**RE: OBJECTION TO RESIDENTIAL DEVELOPMENT WITH IN-FILL
AFFORDABLE HOUSING – REID STREET AND WOODSIDE AVENUE,
LINDFIELD, SSD-79261463**

PPTIES: 2-4 WOODSIDE AVENUE & 1-3 REID STREET, LINDFIELD

This submission relates to the proposed SSD at 2-4 Woodside Avenue & 1-3 Reid Street, Lindfield.

BASEMENT 1

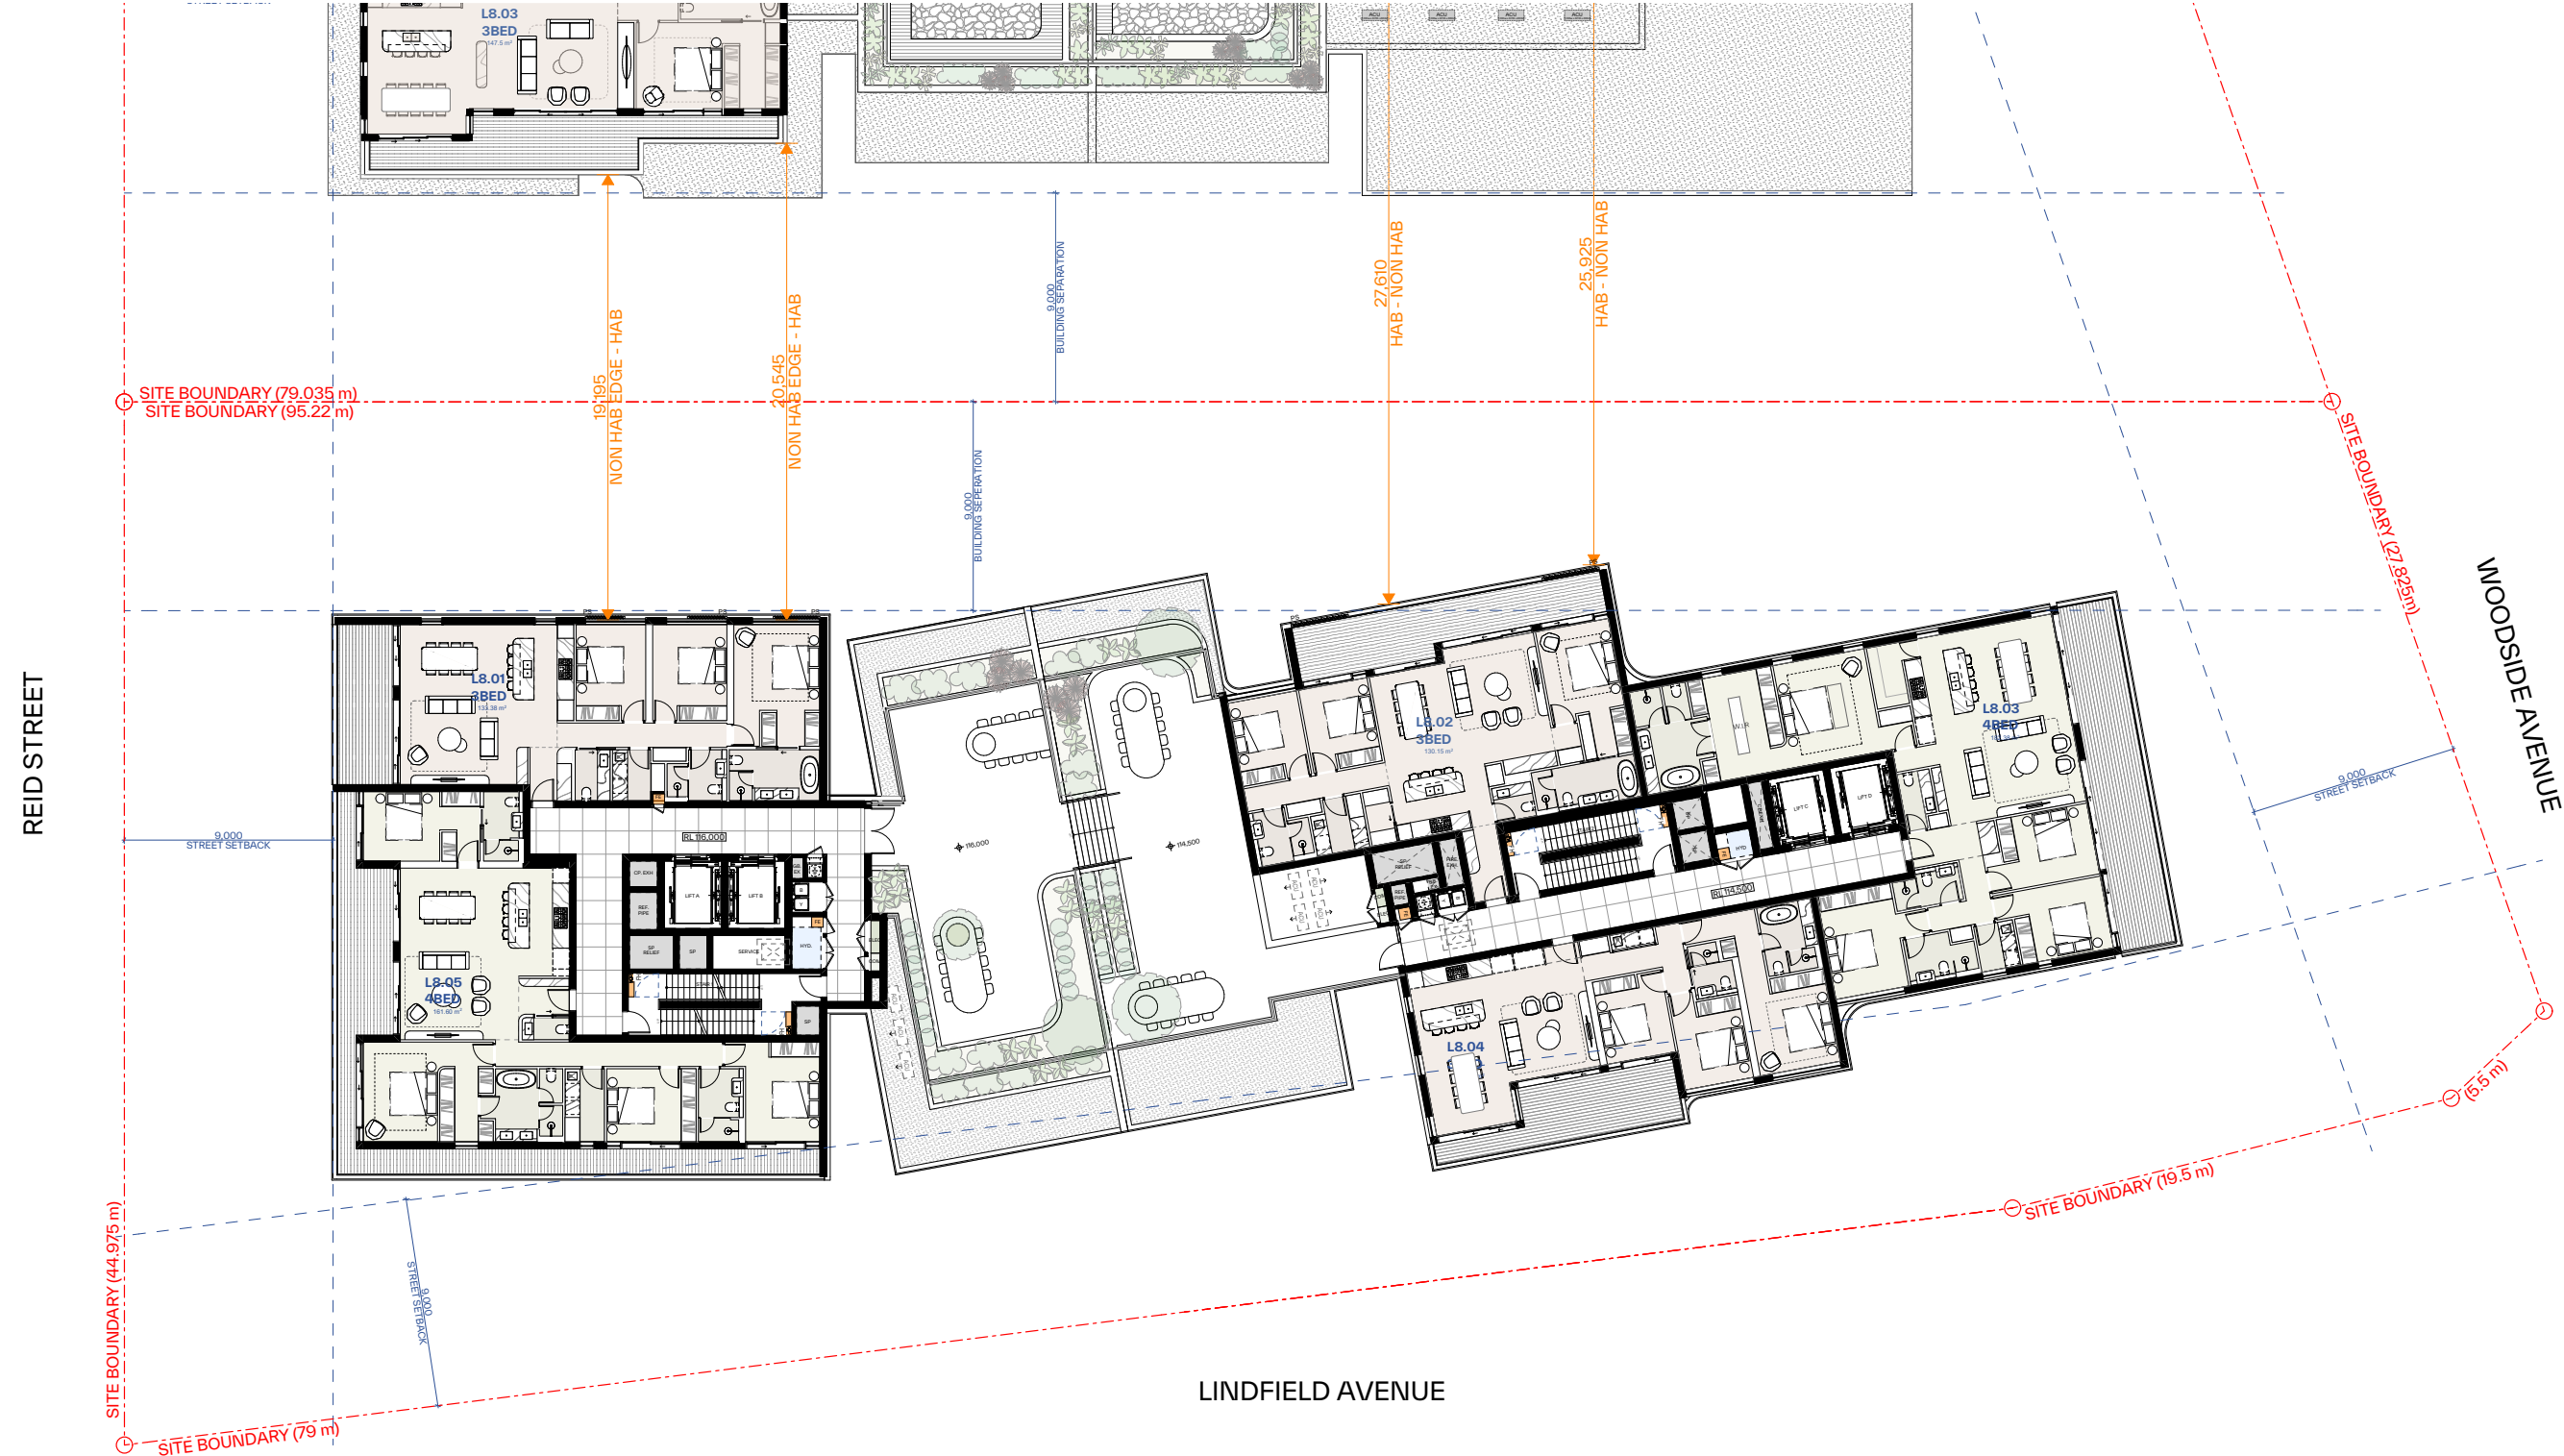
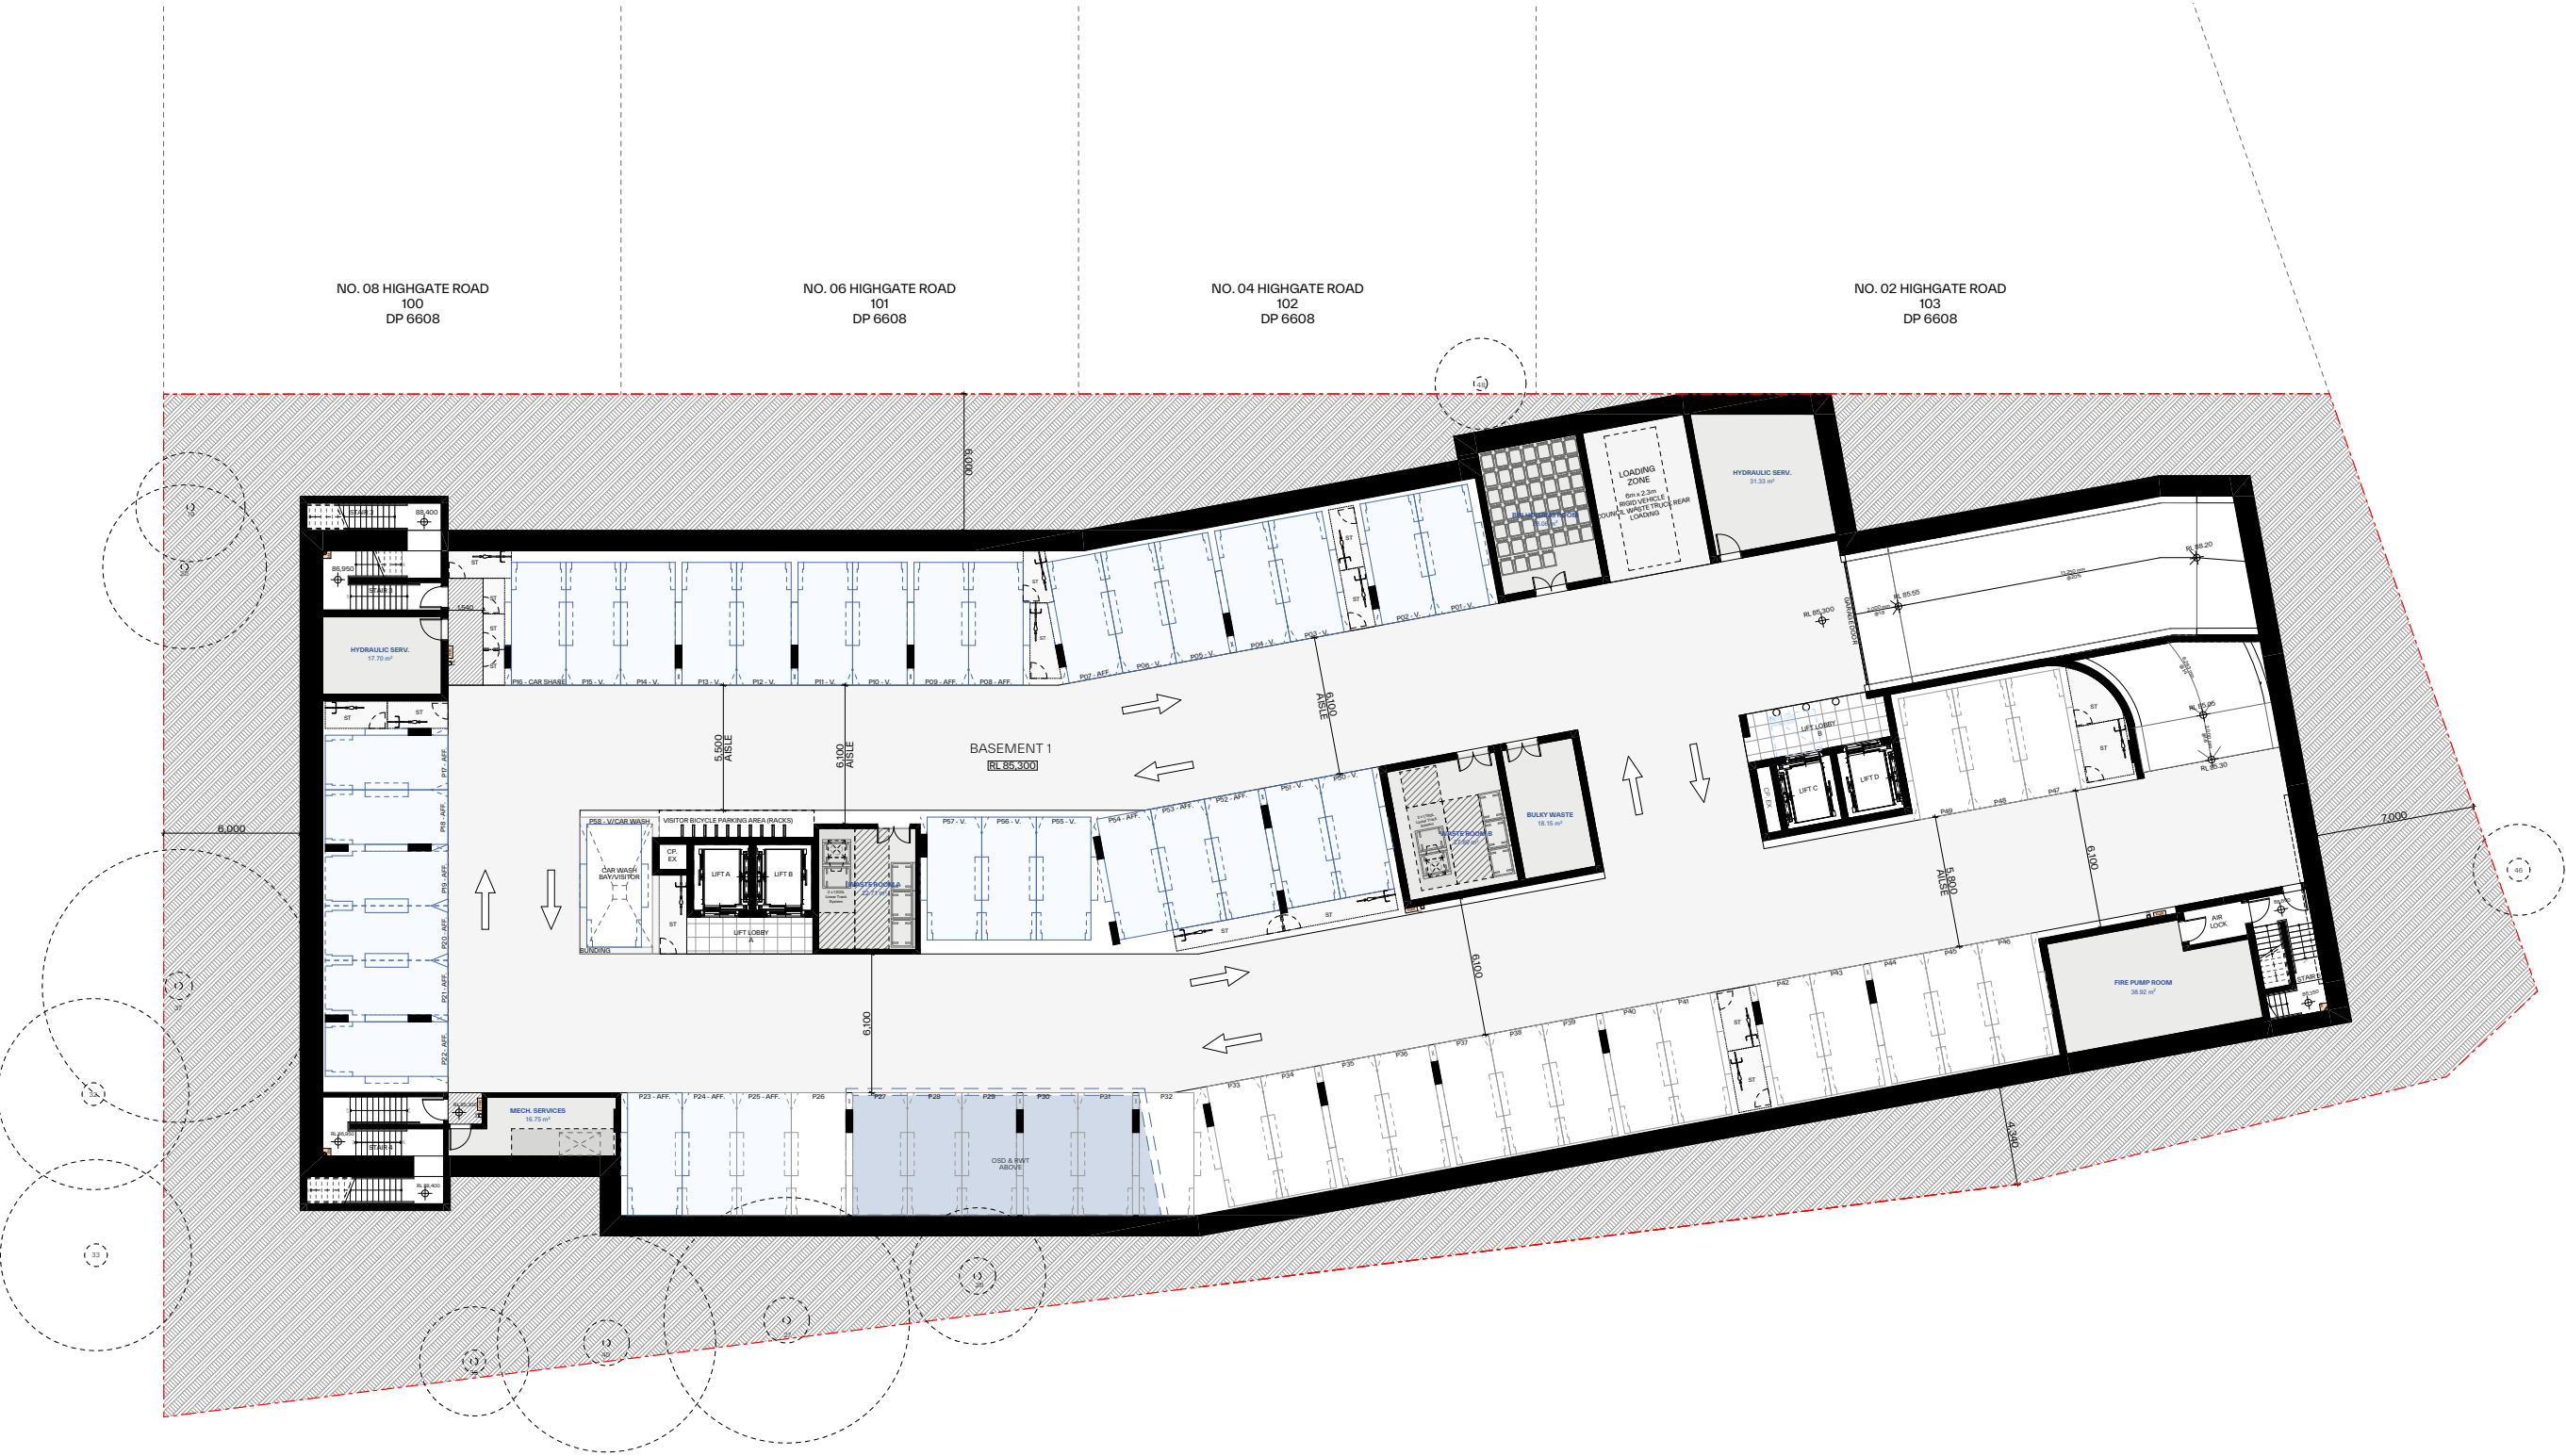
- Objection is raised to the proposed Basement Levels for the following reasons: -
 - i. Part of the proposed Basement Levels is close to part of the eastern Common Boundary and also underneath part of the proposed Deep Soil Zone. This is not in accordance with the definition of Deep Soil Zone under the ADG which does not allow structures underneath the Deep Soil Zone.

- ii. Part of the proposed Basement Levels extend outside of the proposed building footprint above, which is a further breach of the ADG.
- Thus, contrary to the claims in the Applicant's application, there are numerous breaches of the ADG (and other Planning Controls). These breaches generate adverse impacts on the future occupants of the proposed development, as well as generating adverse impacts on existing adjoining owners.

COMMUNAL OPEN SPACE

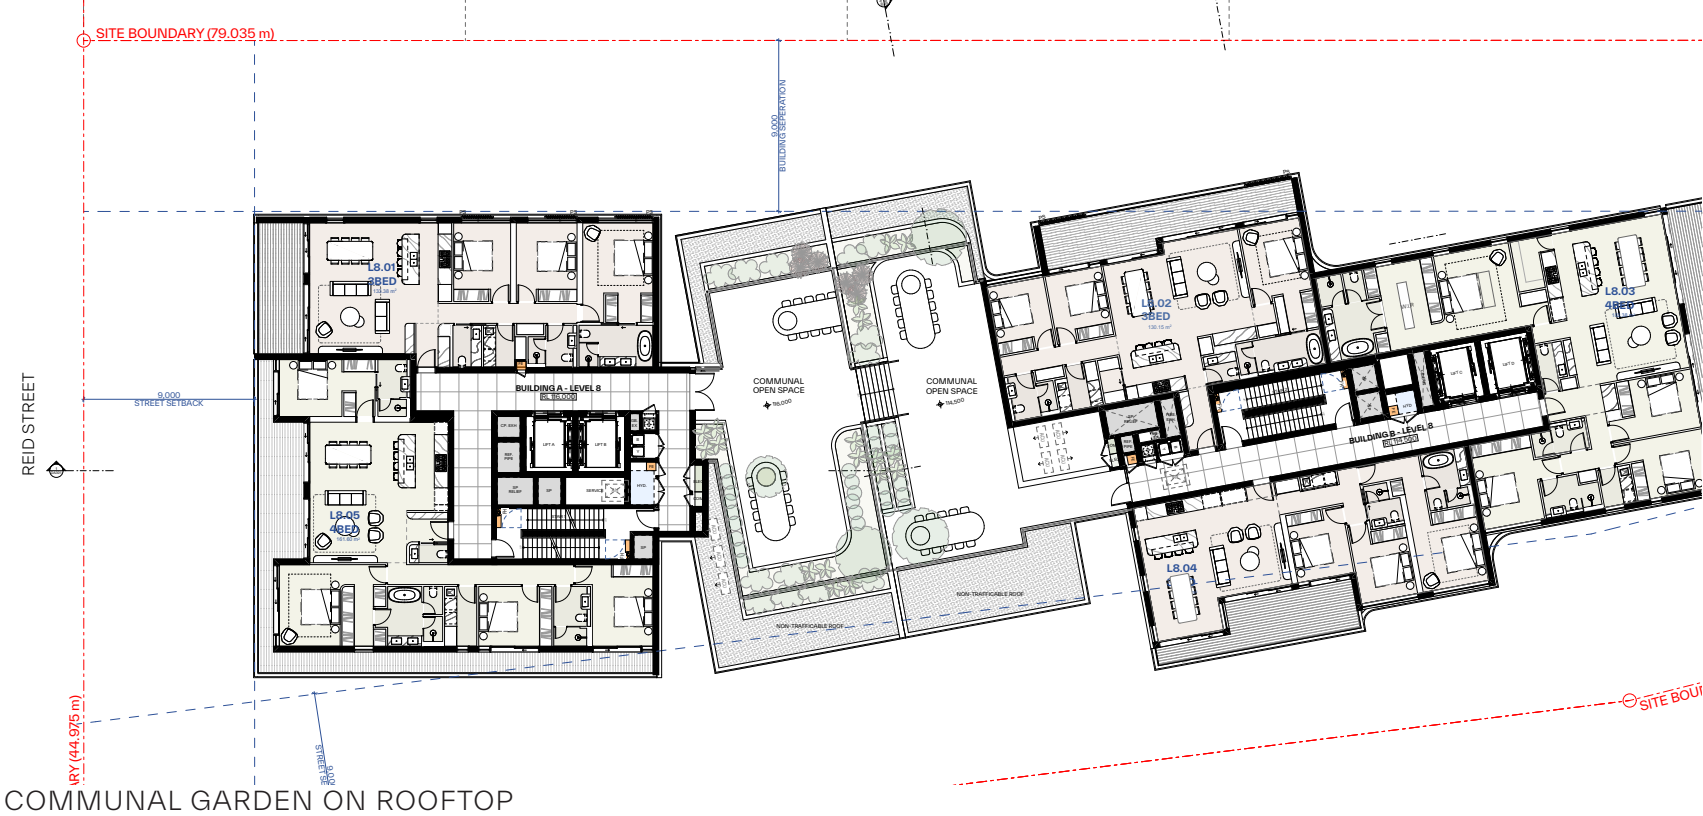
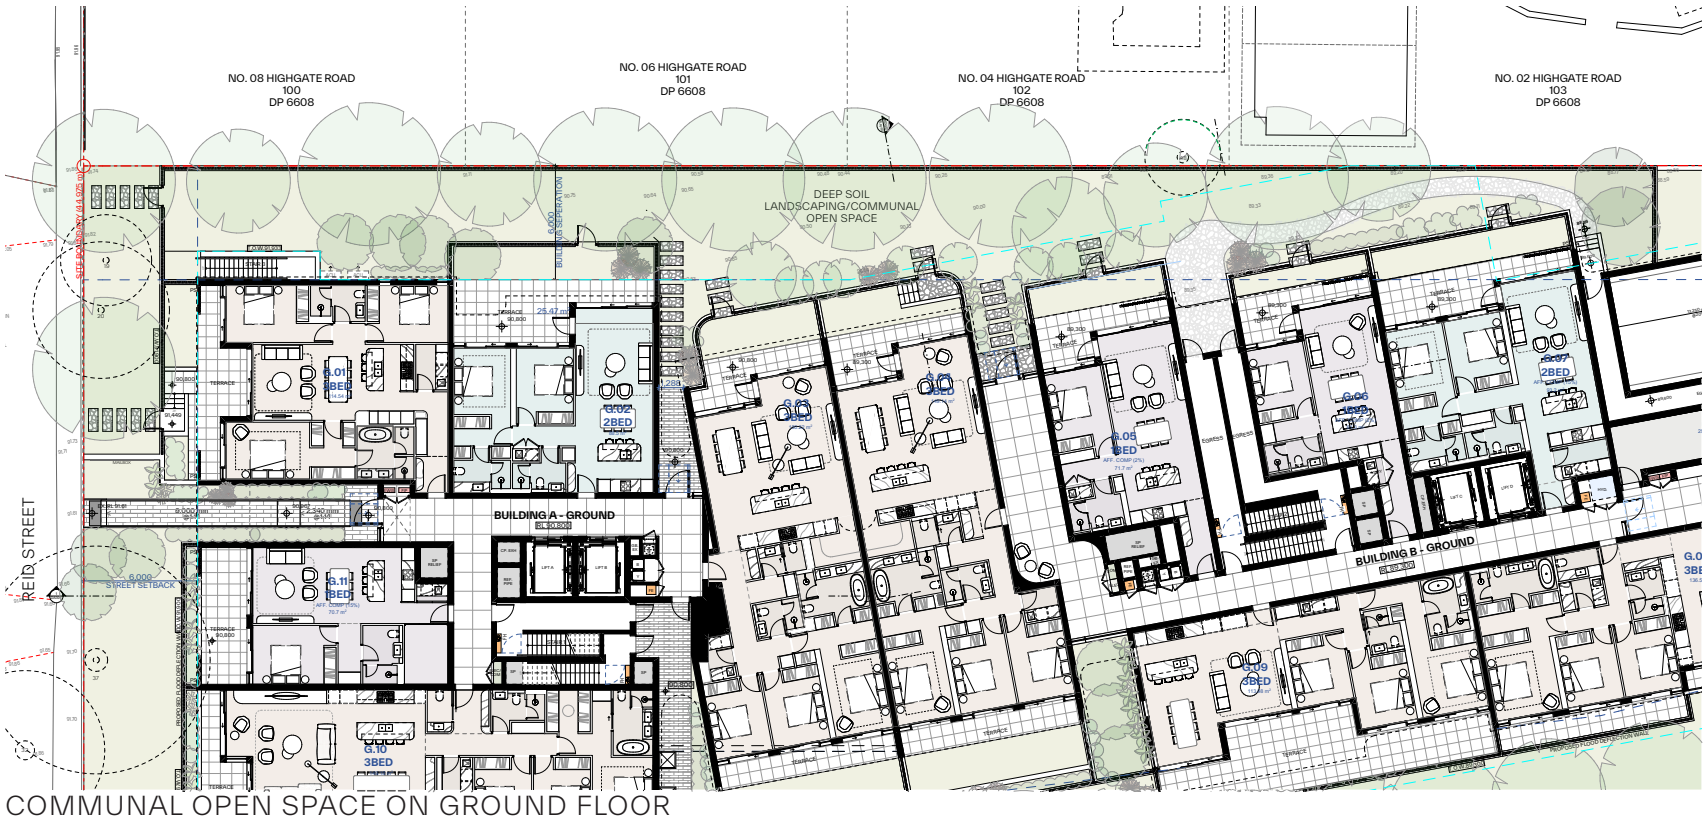
- Breaches of the Communal Open Space (COS) Controls under the ADG in relation to the following: -
 - i. The provision of part of the COS on the proposed rooftop generates adverse Acoustic Impact and Overlooking Impact to adjoining properties which does not achieve the *“high level of amenity”* as required under issue 7 entitled *“Environmental Amenity”*. In fact, the Planning Consultant for the Applicant has advised that *“importantly, no roof top areas are proposed meaning there will be no opportunities for additional Overlooking from shared spaces”*. But this application and the adjoining application both have roof top COS. Thus, the Applicant’s own Planning Consultant has expressed the opinion that roof top open space areas generate adverse Overlooking Impact. In addition, I consider that the roof top COS will also generate adverse Acoustic Impact.

- ii. Part of the COS is also provided within the eastern side setback adjacent to the adjoining proposed development at 2-8 Highgate Road. This eastern COS will be in shade for the great majority of the day and will also be subject to direct Overlooking Impact from the adjoining proposed development at 2-8 Highgate Road.

- iii. Part of the COS is also provided adjacent to the corner of Lindfield Road and Reid Street. This part of the COS will be subject to adverse Overlooking Impact from the public domain unless high screen walls are erected which would have a consequential adverse Streetscape Impact. The same is true for the proposed COS fronting Lindfield Road and Woodside Avenue. Both of the proposed COS areas will also be subject to noise from passing traffic and passing trains.
